Recommendation Report for Planning Permission

REF NO: LU/1/18/PL

LOCATION: 53 East Street
Littlehampton
BN17 6AU

PROPOSAL: Two storey extension. This application affects the character & appearance of the East Street Conservation Area & may affect the setting of Listed Buildings.

client	project	drawing	date	drawn	drawing no	revision
East Street Dental Surgery	Extension at 53 East Street, Littlehampton, BN17 6AU	Alternative Proposed Elevations	Sept 16	pd	0228 / 104	A
			scale	CAD file name:		
			1:100 @ A3

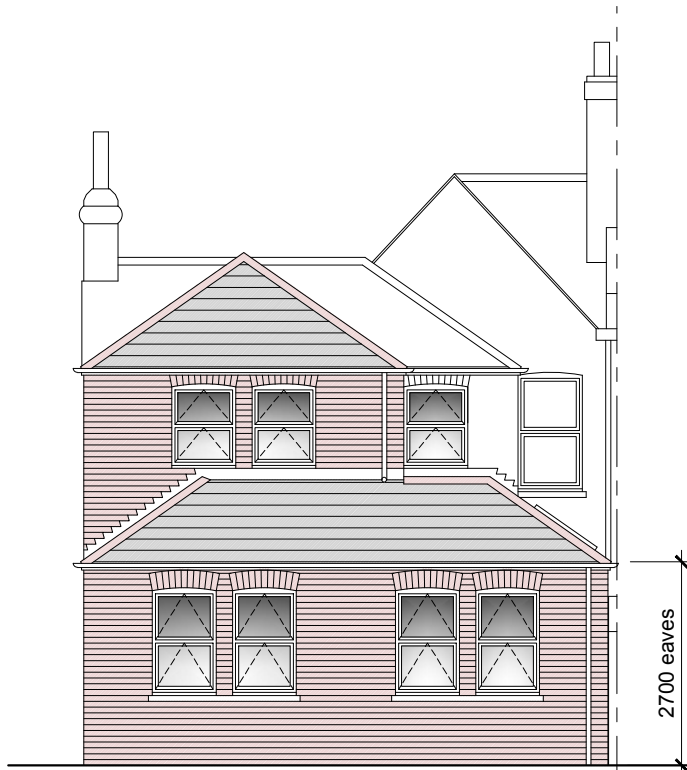
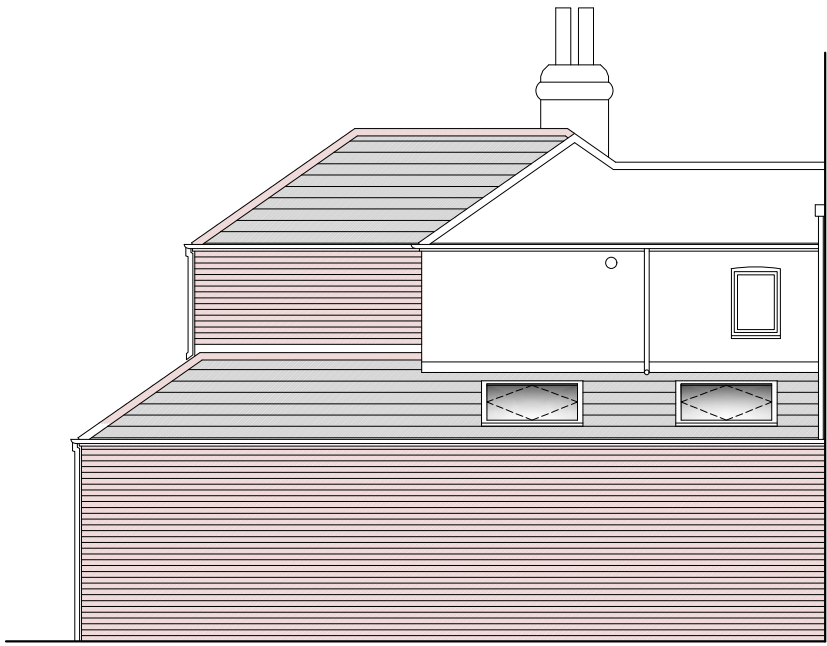
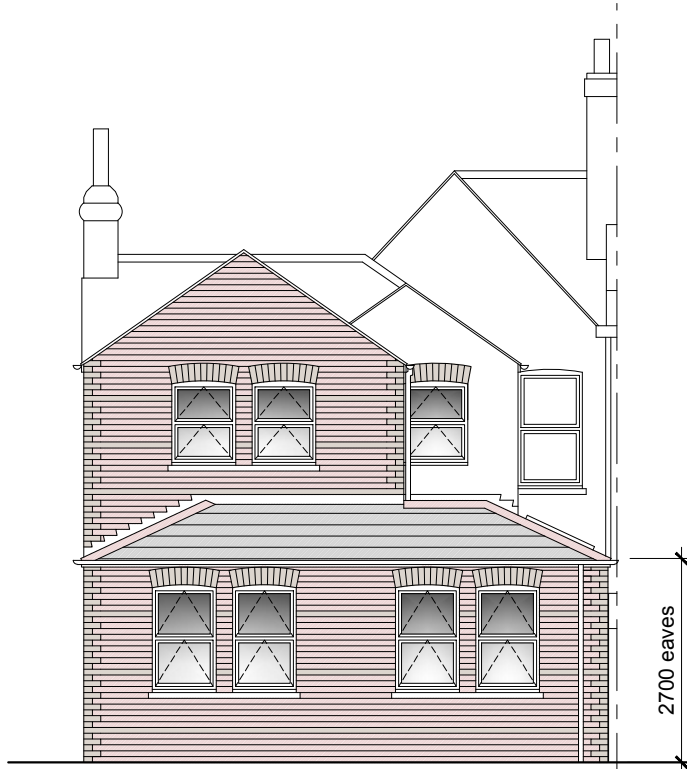
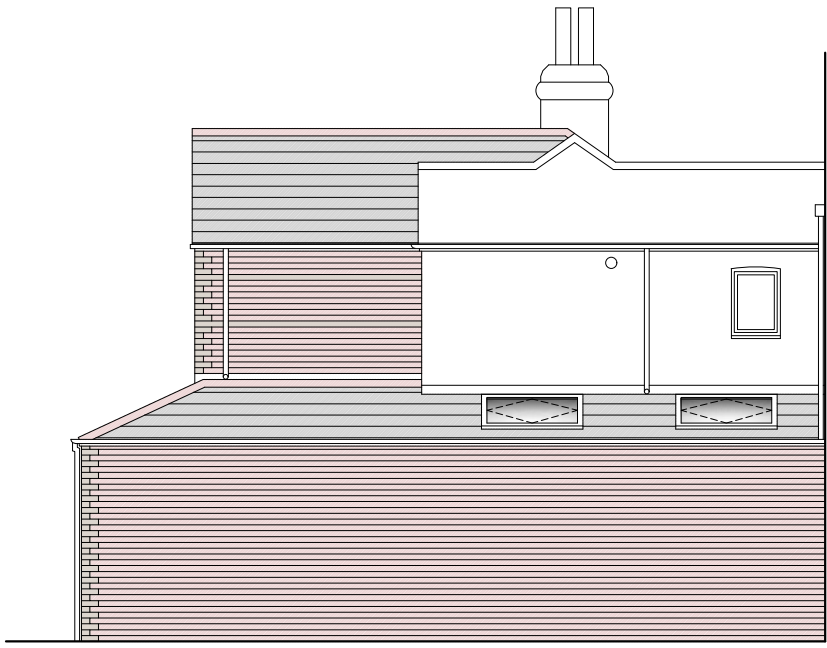
The revisions to the proposal are:

1. String courses and quoins to tie in with original features.
2. Ground floor extension roof height reduction to reduce impact on rear gable appearance.
3. Rear gable in place of hipped roof.

The Conservation Officer has agreed that these revisions result in a more sympathetic and acceptable scheme. Which is well integrated with the existing building and surrounds. The proposals are not considered to be harmful to the Building of Special Character.
